TIERRA WEST, LLC

March 17, 2016

**RE: LOT 2A & 3A DEL NORTE PLAZA
GRADING AND DRAINAGE PLAN
ENGINEER'S STAMP DATE 2-17-2016 (C18-D042D)**

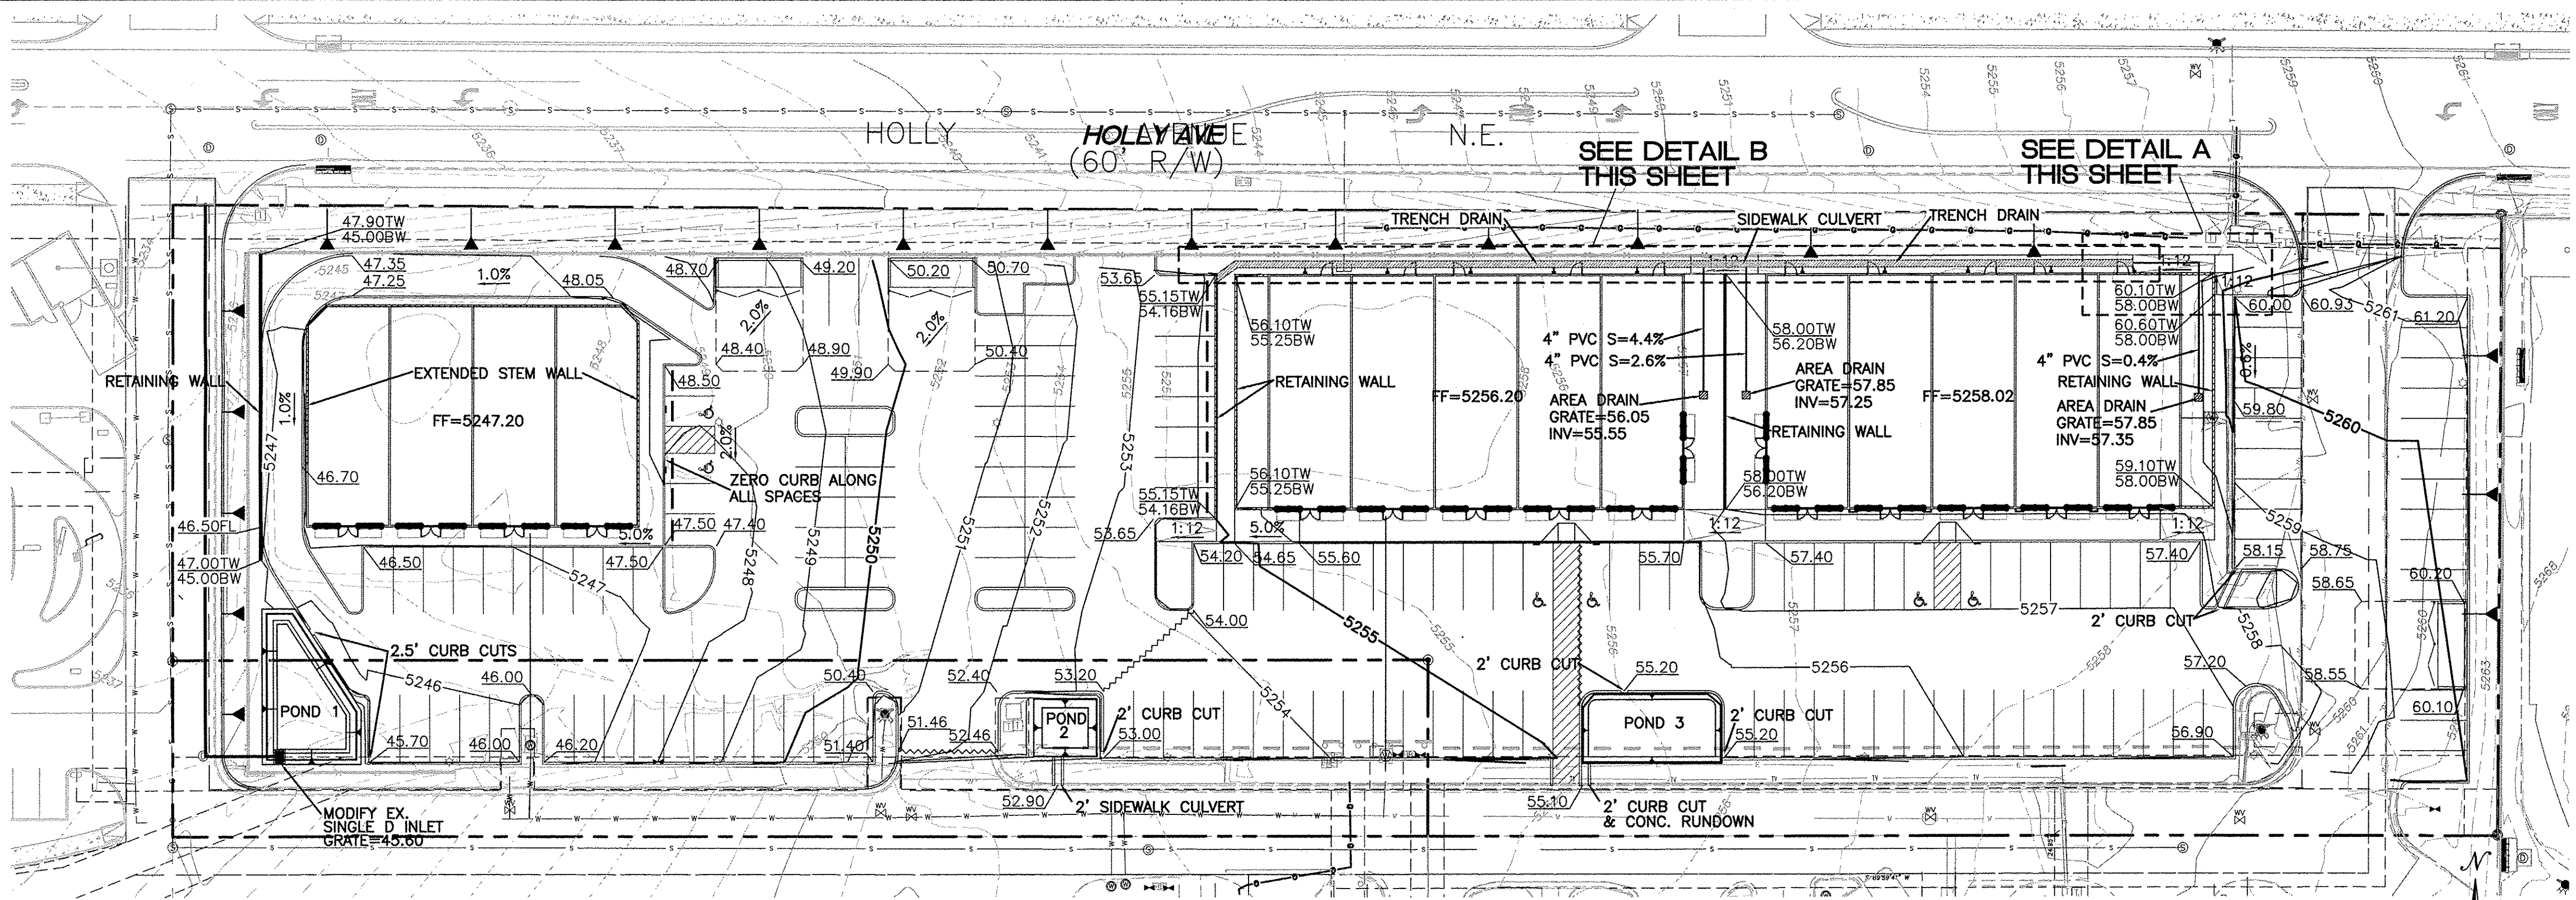
3. The existing inlet in the proposed "Pond 1" is called to be modified. Clarify what the modification involves.
 - a. The grate is shown on the slope of the pond; it is assumed that the box will be perched to ensure that the inlet elevation is level and set at EL 45.60 as called out.

4. Provide benchmark information, unless it is called out on a different sheet of the construction set.
Response: Benchmark Information has been added and can be seen on the SE corner of the site.

7. We recommend shifting the 12:1 wheelchair ramp that is in front of the easternmost retail space of the larger building slightly to the west so that the top of the ramp lines up with the parking curb; this would remove a potential tripping hazard and provide a better turning space for wheelchairs at the top of the ramp.

Response: The modification to the existing inlet is to raise the grate elevation from 42.45 to 45.60. This modification has been called out on the plan to be raised and perched.

Response: The wheelchair ramp in the mentioned location has been shifted slightly towards the west to line up with the parking curb.

DETAIL B - TRENCH DRAIN DETAIL

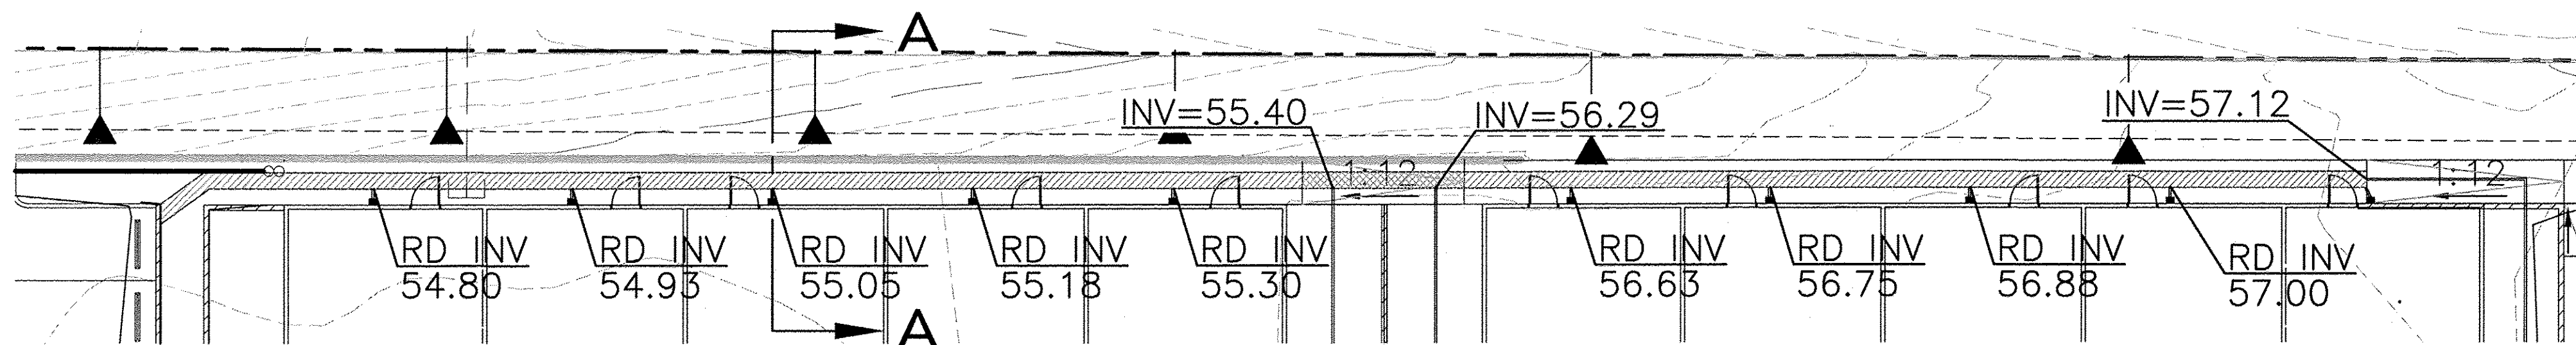
5. Detail B describes the use of a trench drain to provide an outfall for the roof drains of the larger building. A type of grate should be called out that complies with ADA standards and is "heel safe", since it is proposed along the center of the sidewalk. If the sidewalk is intended to drain to the west (without needing to enter the trench drain) we recommend calling out a solid metal top.

Response: As discussed with you on the phone, Section A-A has been updated to call out the metal grate to be ADA compliant and "Heel Safe". Because the sidewalk would be draining into the trench drain, the metal grate has also been called out to be an open grate.
